| FOREST LAKES FILING NO. 5, 6 & 7 GRADING INDEX REFERENCE SHEET | | | |
| PRE-DEVELOPMENT GRADING AND EROSION CONTROL PLAN | | | |

FOREST LAKES FILING NO. 5, 6 & 7
GRADING INDEX REFERENCE SHEET
PRE-DEVELOPMENT GRADING AND
EROSION CONTROL PLAN

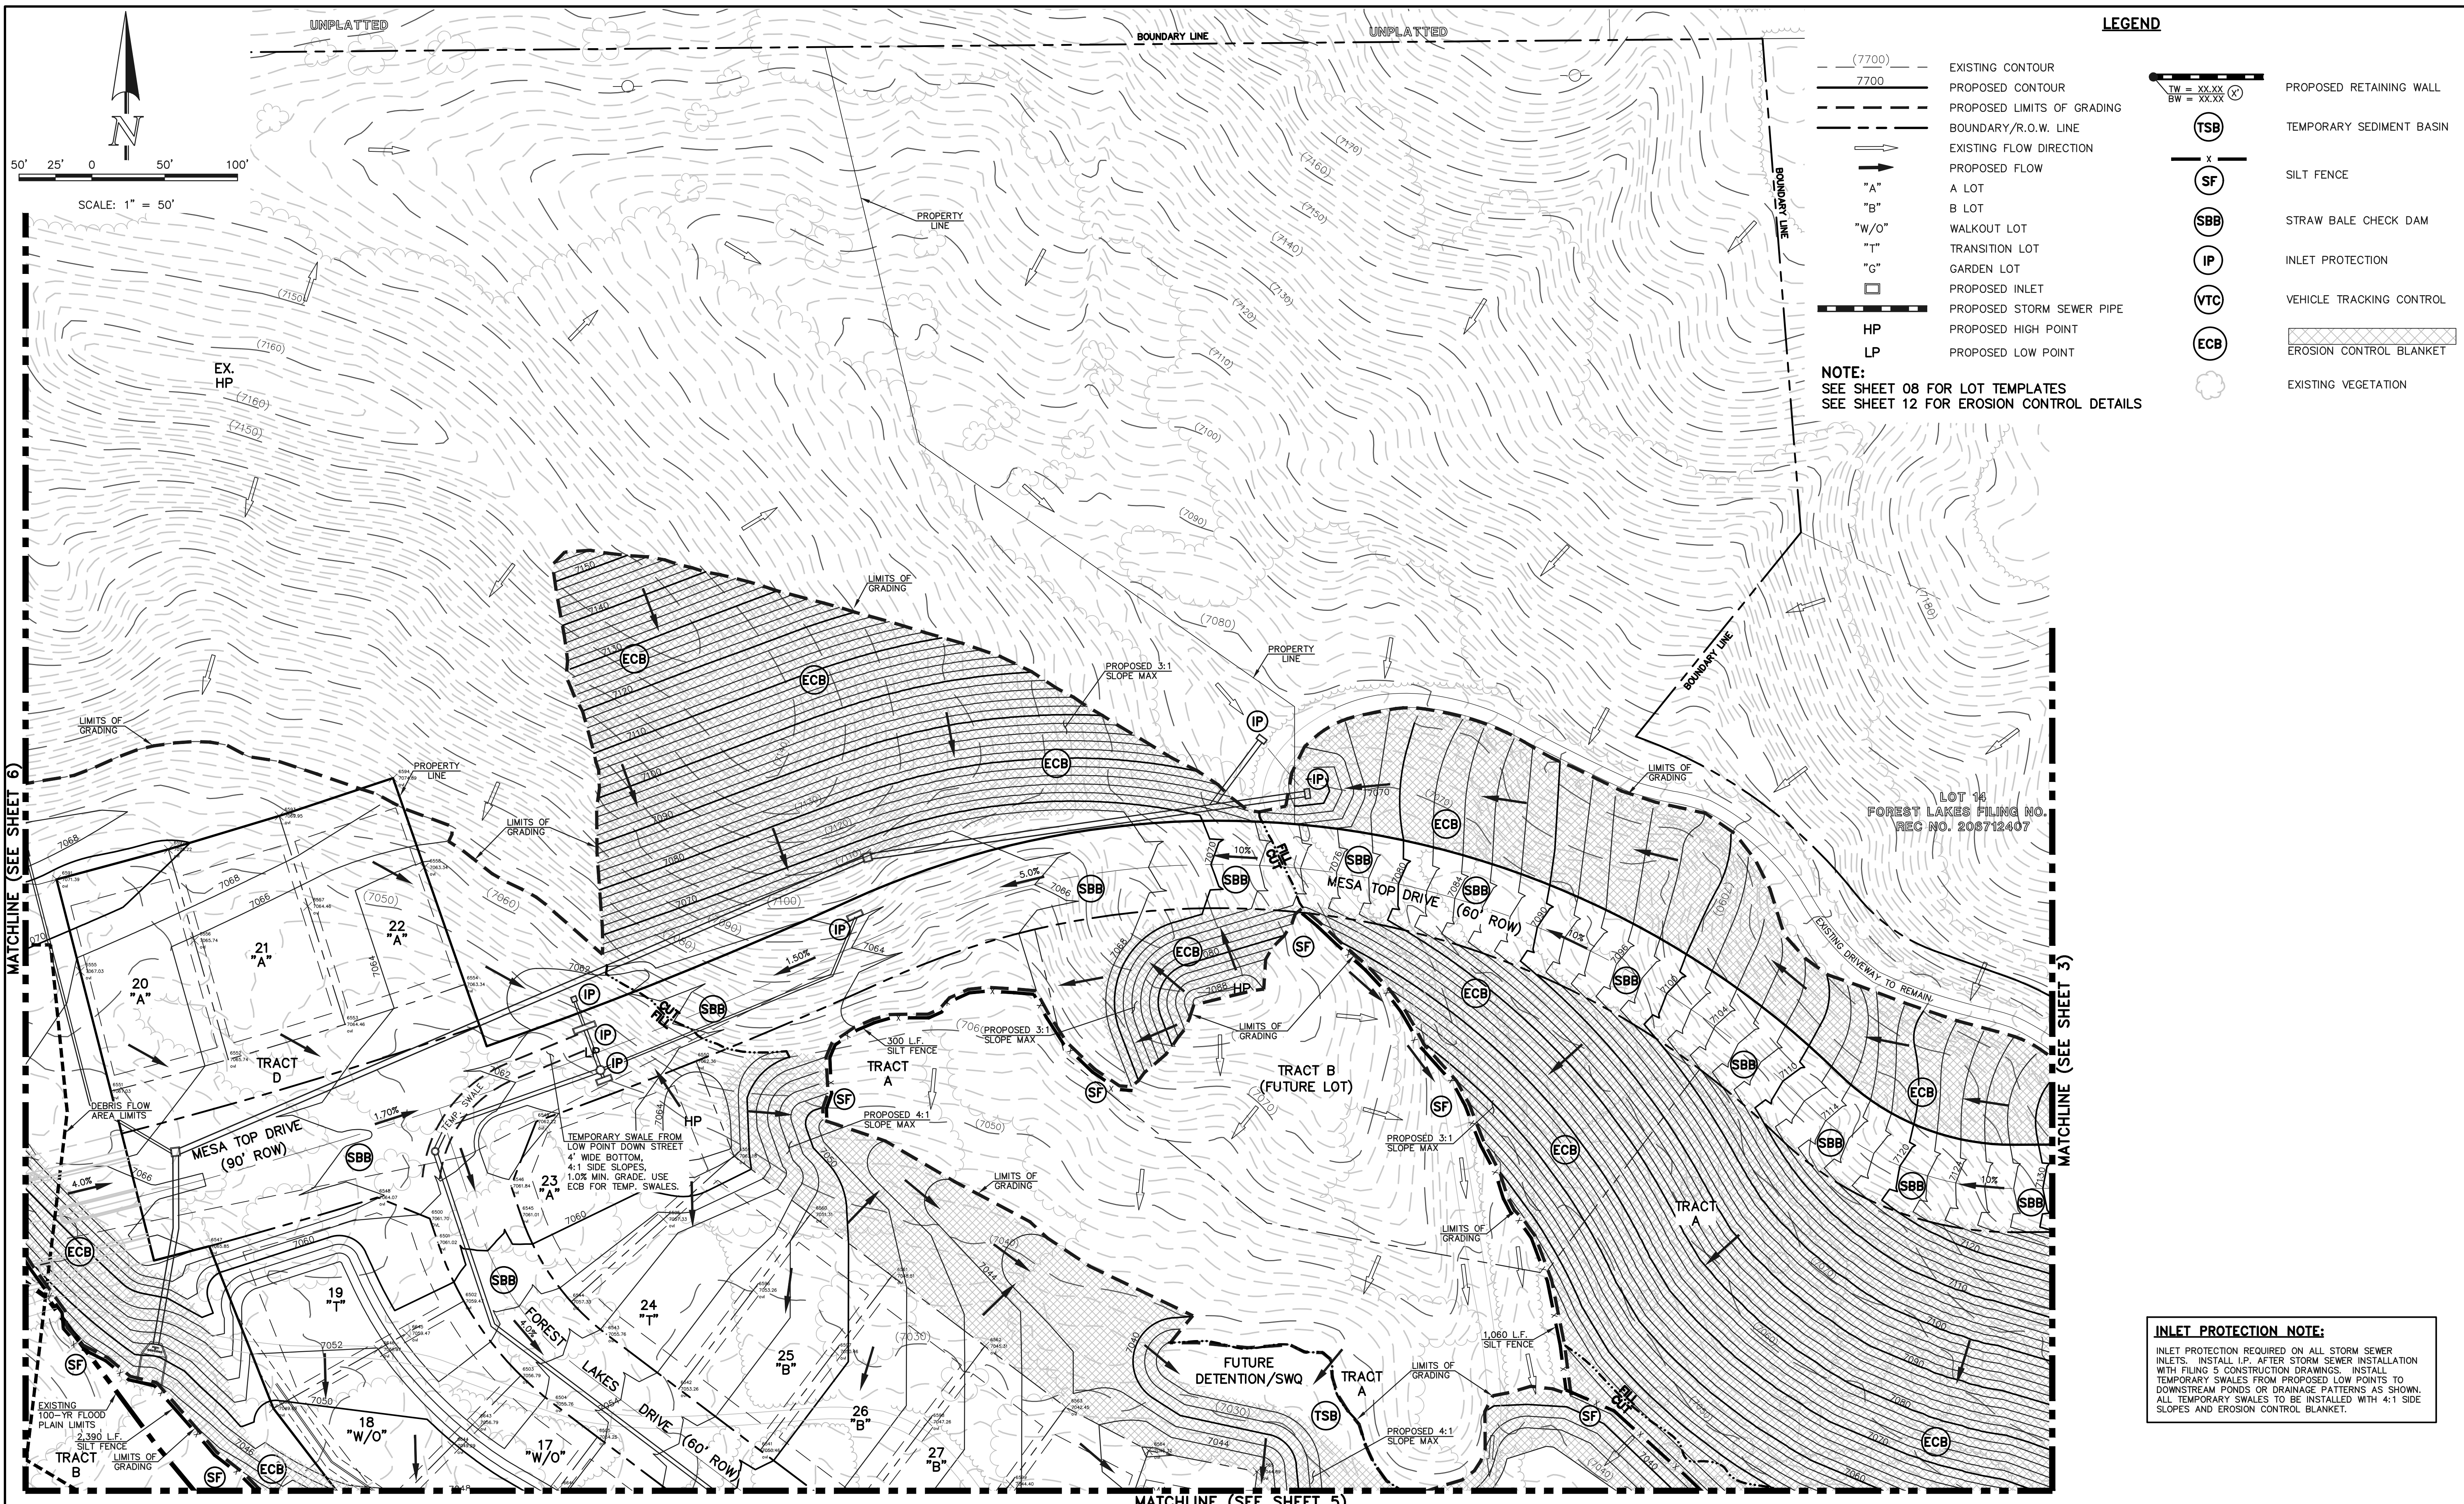
Contours shown appears to be finished grade elevation, not subgrade for early grading. Either modify to show subgrade contours or provide a typical cross section detail noting the subgrade grading associated with this plan relative to the finished grade shown on the plans. Example of what another application provided. Unresolved.

DESIGNED BY	MAL	SCALE	DATE	05/21/19
DRAWN BY	BB	(H) 1" = 50'	SHEET	6 OF 13
CHECKED BY		(V) 1" = N/A	JOB NO.	1175.50

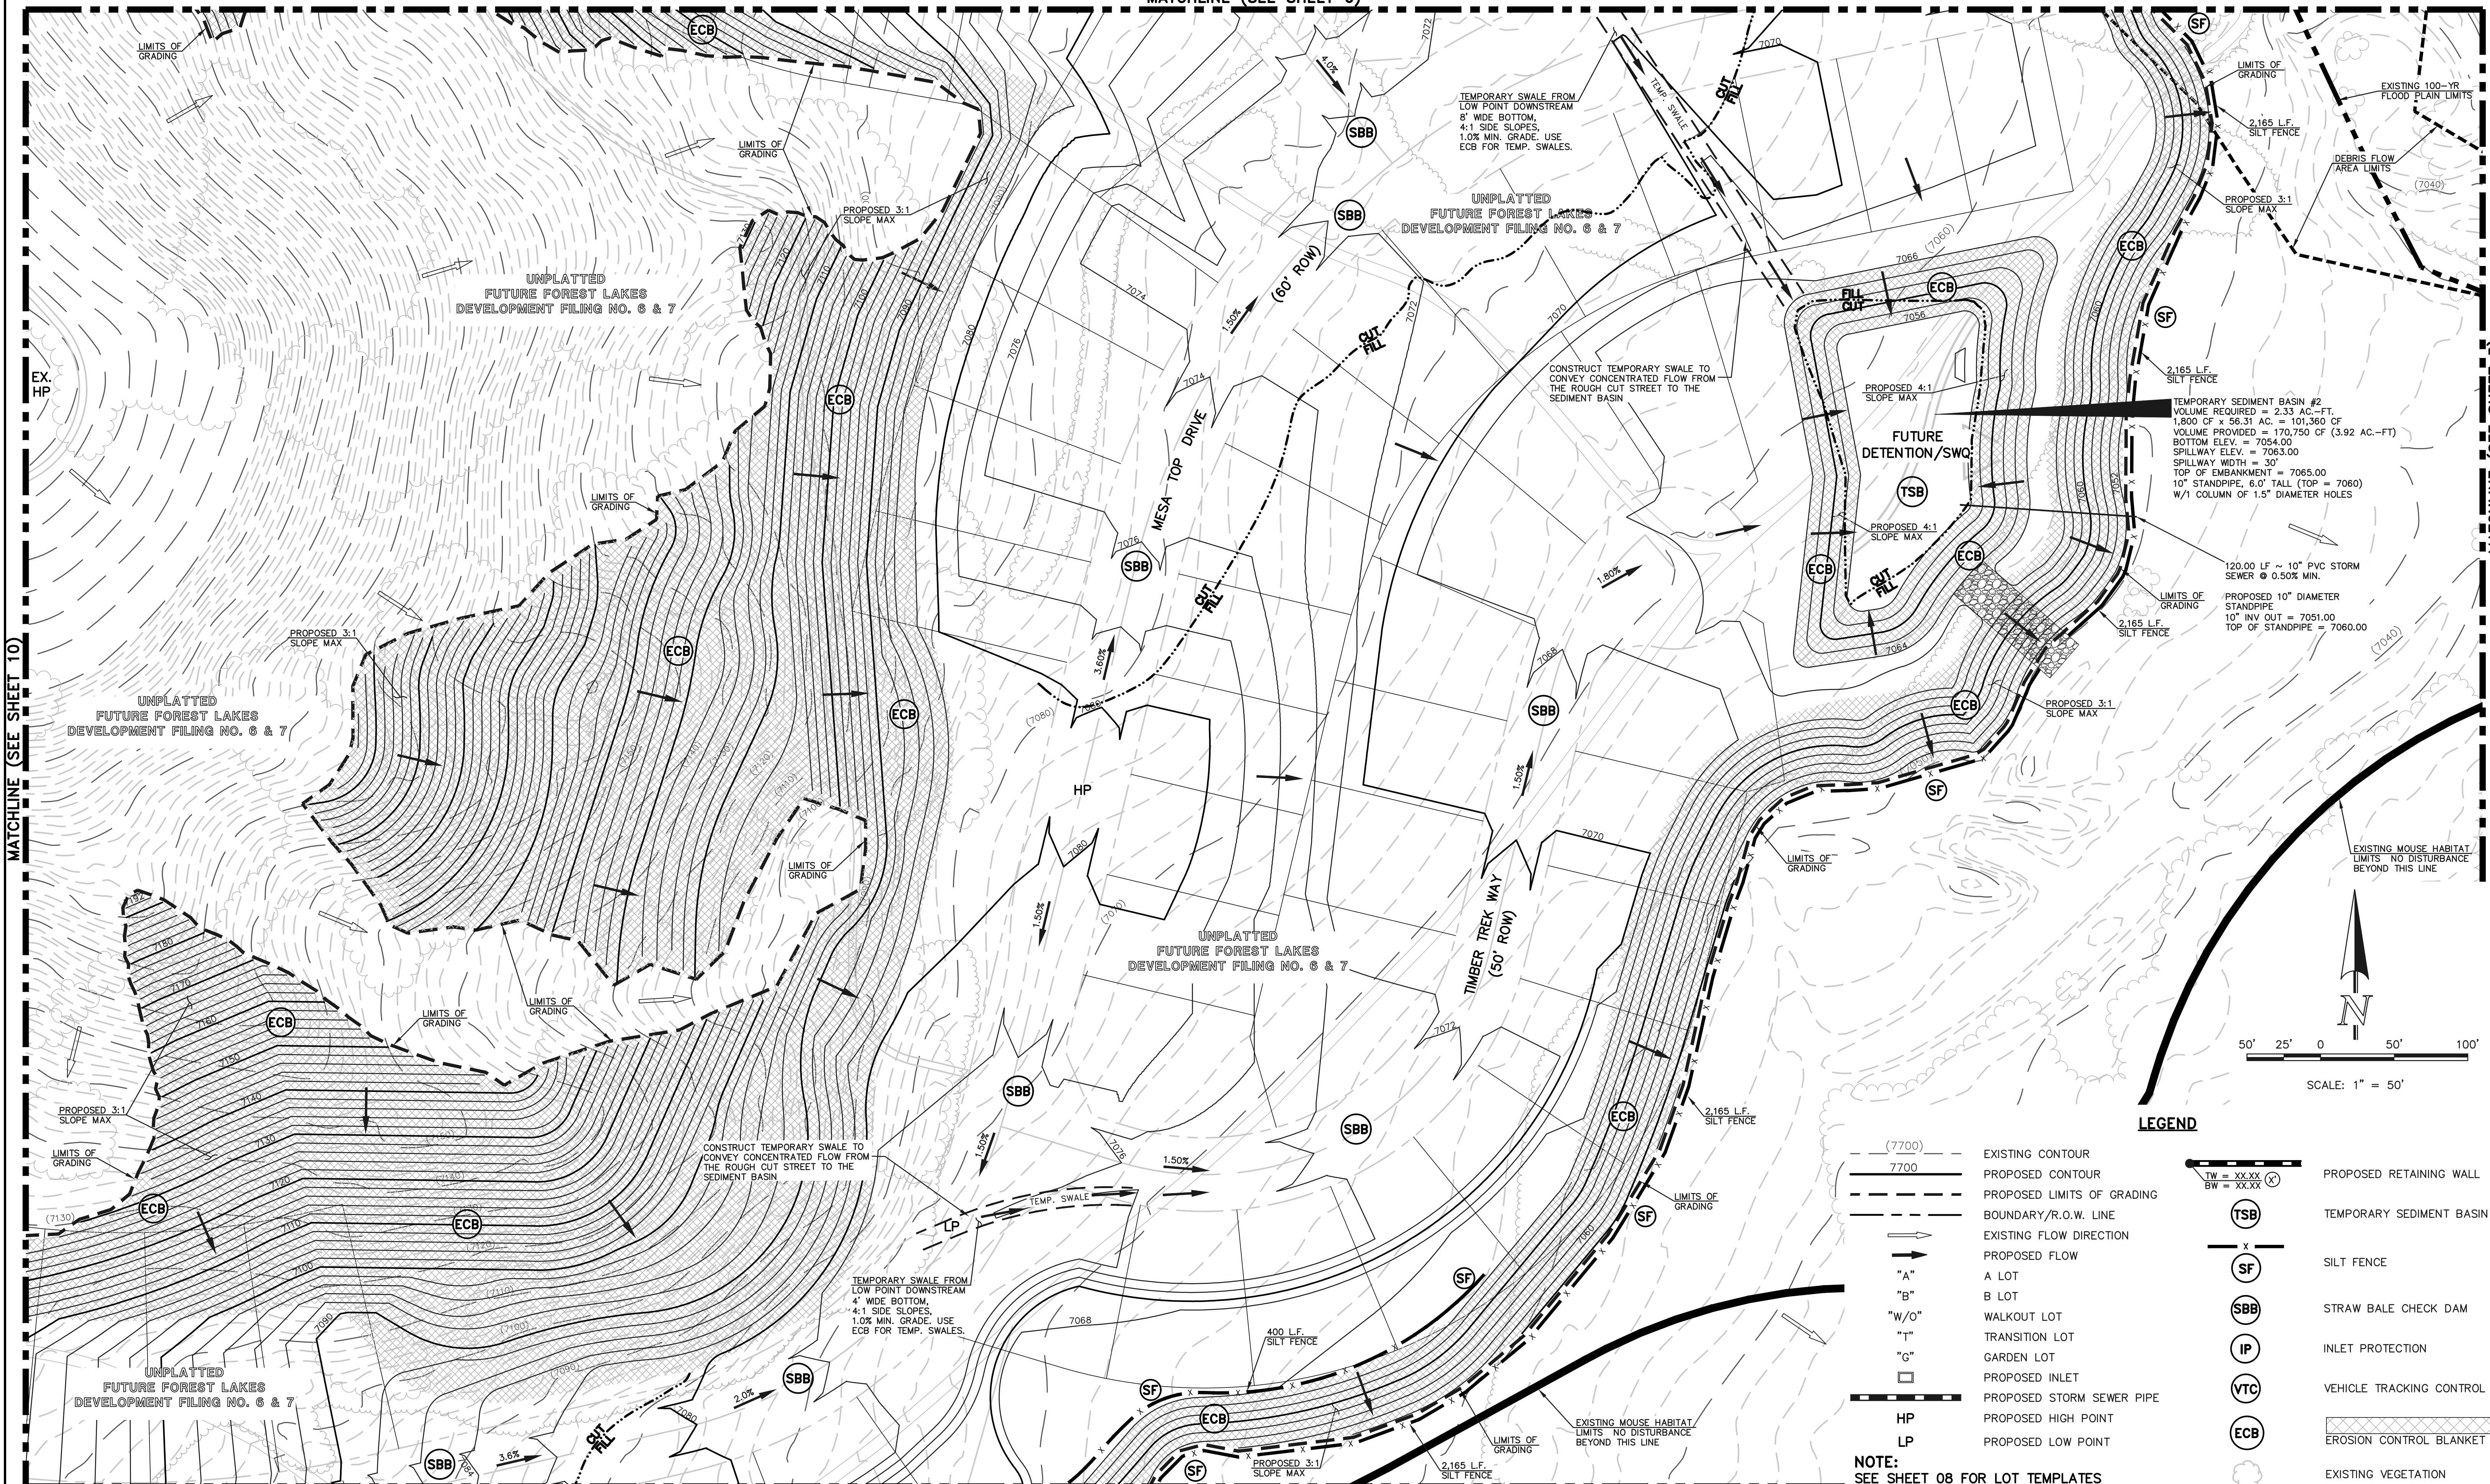
Provide detailed information (note or detail drawing) regarding the temporary swale: side slope, min/max slope, min depth, lining (grass or ECB or riprap), etc.

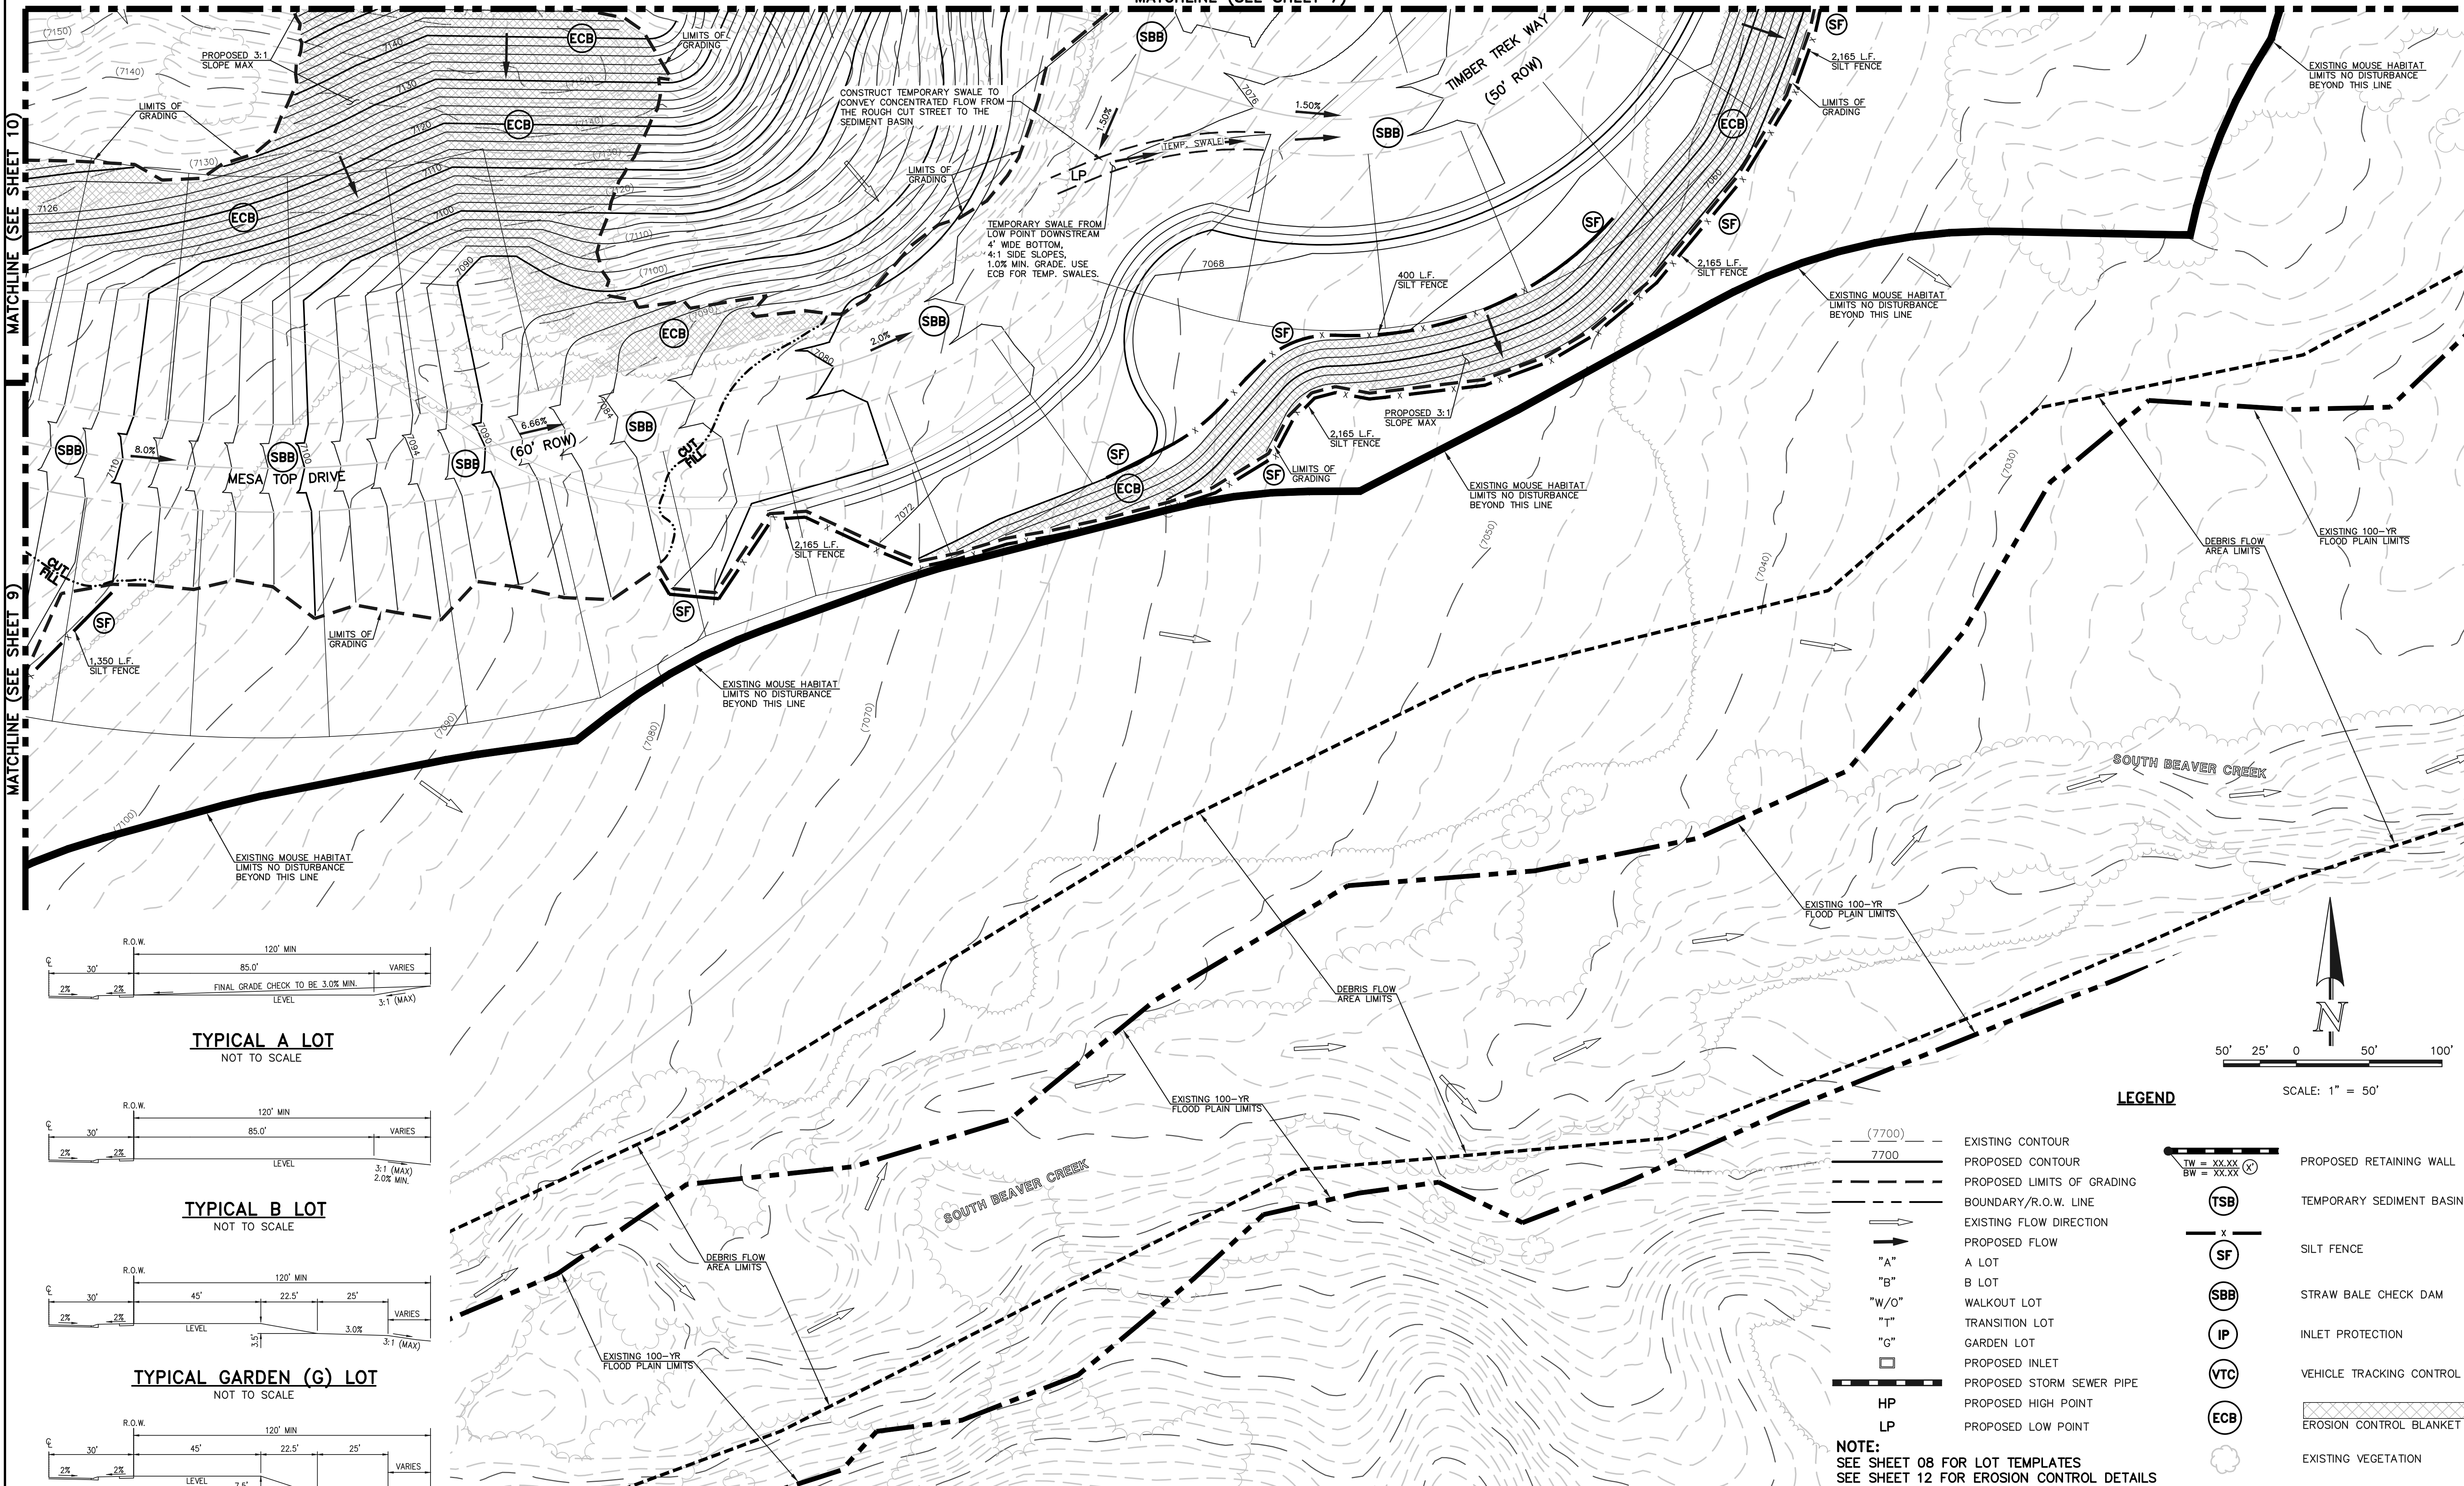
Provide detailed information (note or detail drawing) regarding the temporary swale: side slope, min/max slope, min depth, lining (grass or ECB or riprap), etc.
